Re: Albuquerque Studios Master Plan Development
Traffic Impact Study
Report date October 13, 2021, HT#R16DA3006A
Engineer's Stamp 10/13/2021

The subject Traffic Impact Study received on October 13, 2021, has been reviewed by the City. The following comments are to be addressed satisfactorily before final approval by the City of Albuquerque Planning Development Transportation Section.

Intersection 9: Eastman/Mesa del Sol Blvd.

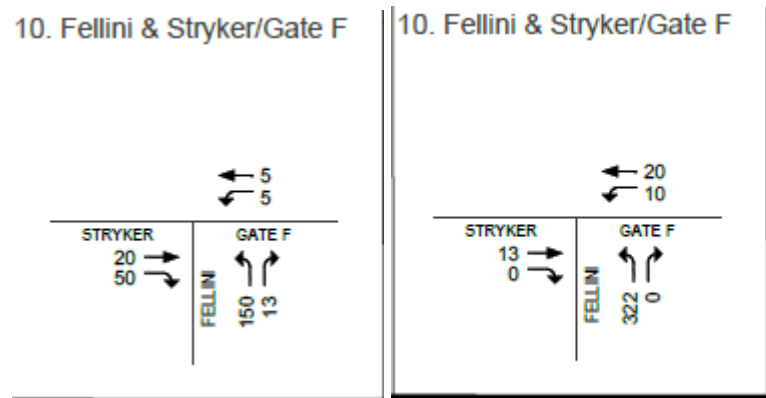
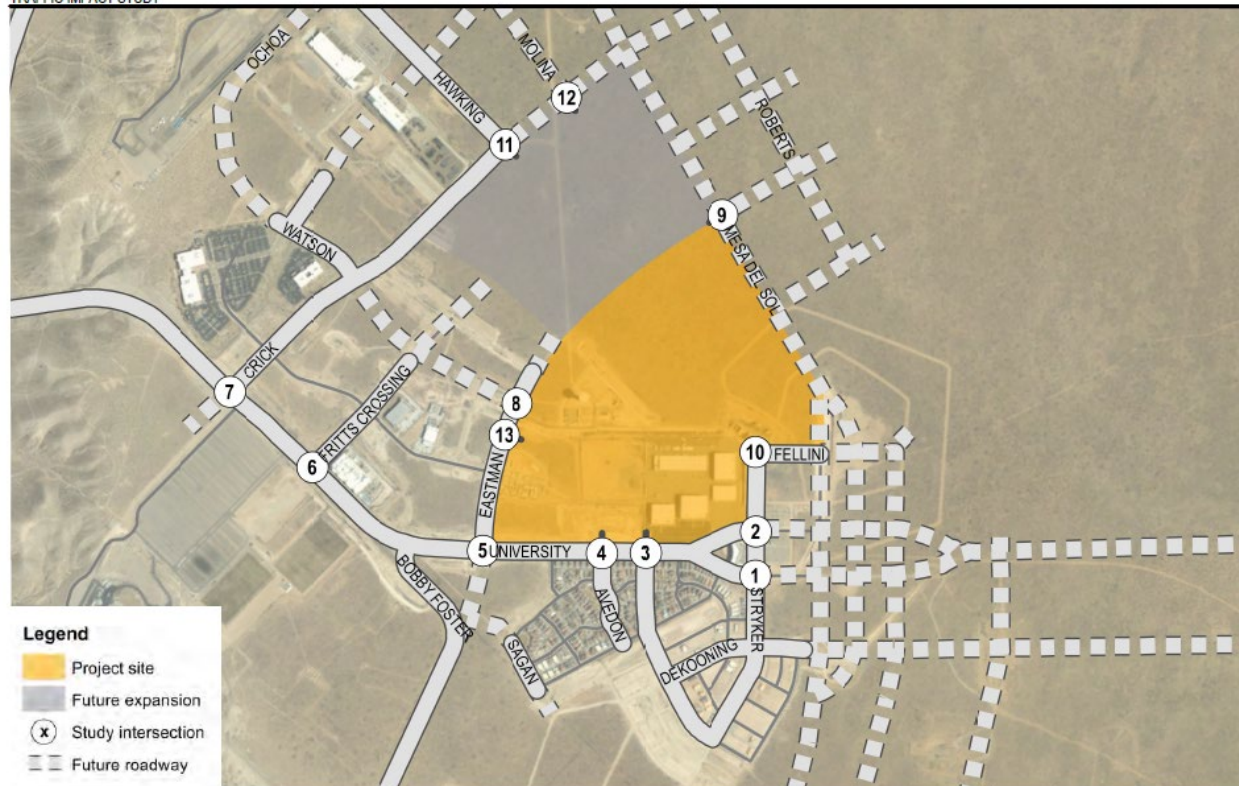
Intersection 9: Eastman/Mesa del Sol Blvd.

- NB left – (Netflix traffic)- not feasible
- EB right (Netflix traffic)

Intersection 9: Eastman (Gate E) Eastbound / Mesa del Sol Blvd. (NB/SB)

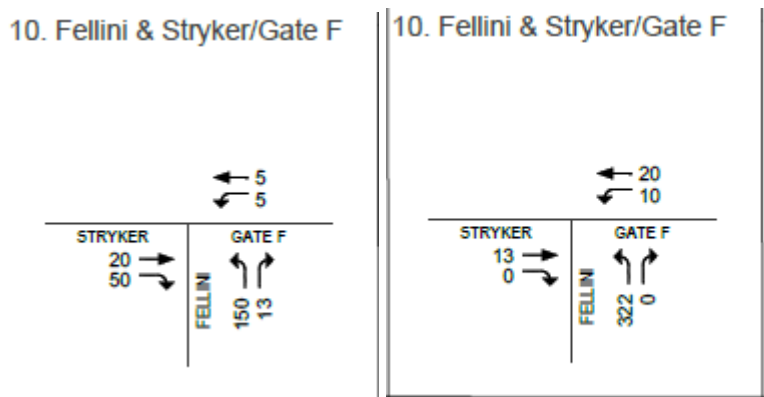
Intersection 9: Eastman/Mesa del Sol Blvd.

- NB right - (Netflix traffic)
- SB left - (Netflix traffic)

- WB right - (Netflix traffic)
- WB left - (Netflix traffic)
